**Subject:** FW: Consultation on planning application. Chancellors School, Brookmans Park 6/2020/2581/FULL

**From:** Ania Jakacka [mailto:Ania.Jakacka@hertfordshire.gov.uk]  
**Sent:** 28 January 2021 16:19  
**To:** David Elmore  
**Cc:** Admin  
**Subject:** RE: Consultation on planning application. Chancellors School, Brookmans Park 6/2020/2581/FULL

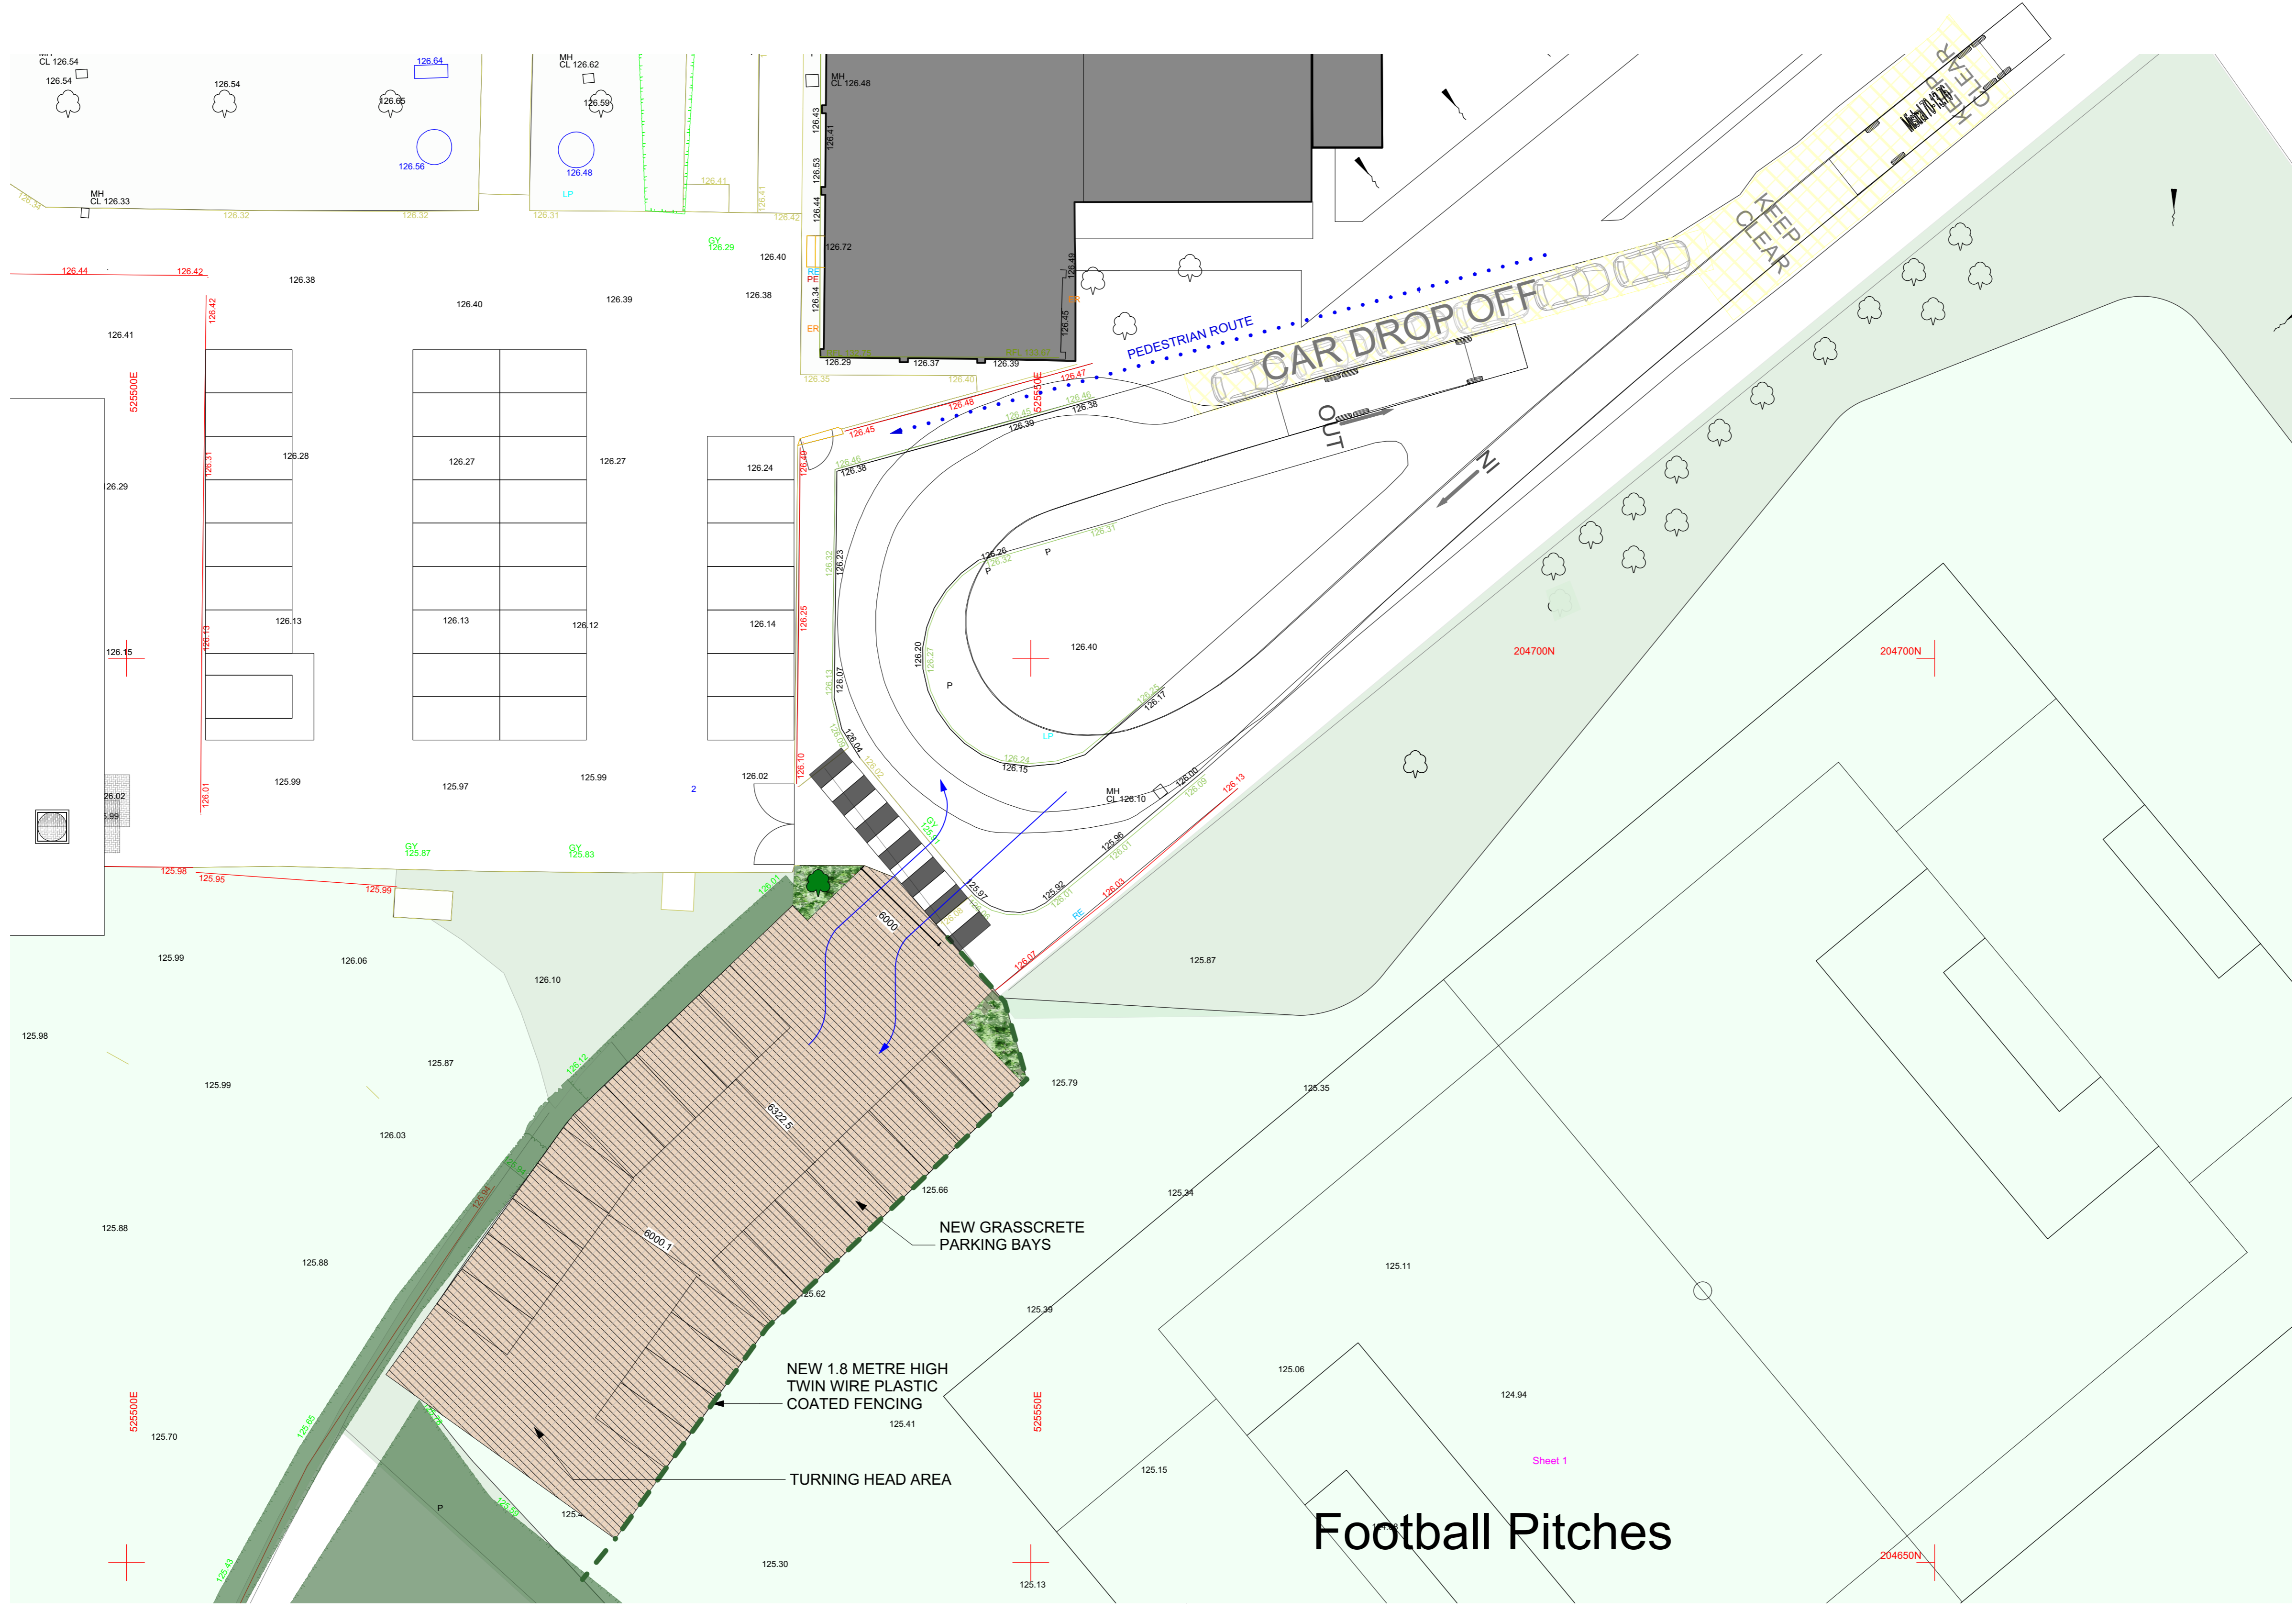
I have just discussed the issues raised in my email below with David (copied into this email) and I am satisfied that apart from one issue (the lack of turning area at the back of the temporary car park, which can be addressed by removal of the two last spaces from the plans), all of the other matters have been satisfactorily addressed (most of them relate to the plans which have already been approved as part of the previous application, i.e. zebra crossing, bus tracking, etc). I would therefore like to withdraw my previous objection.
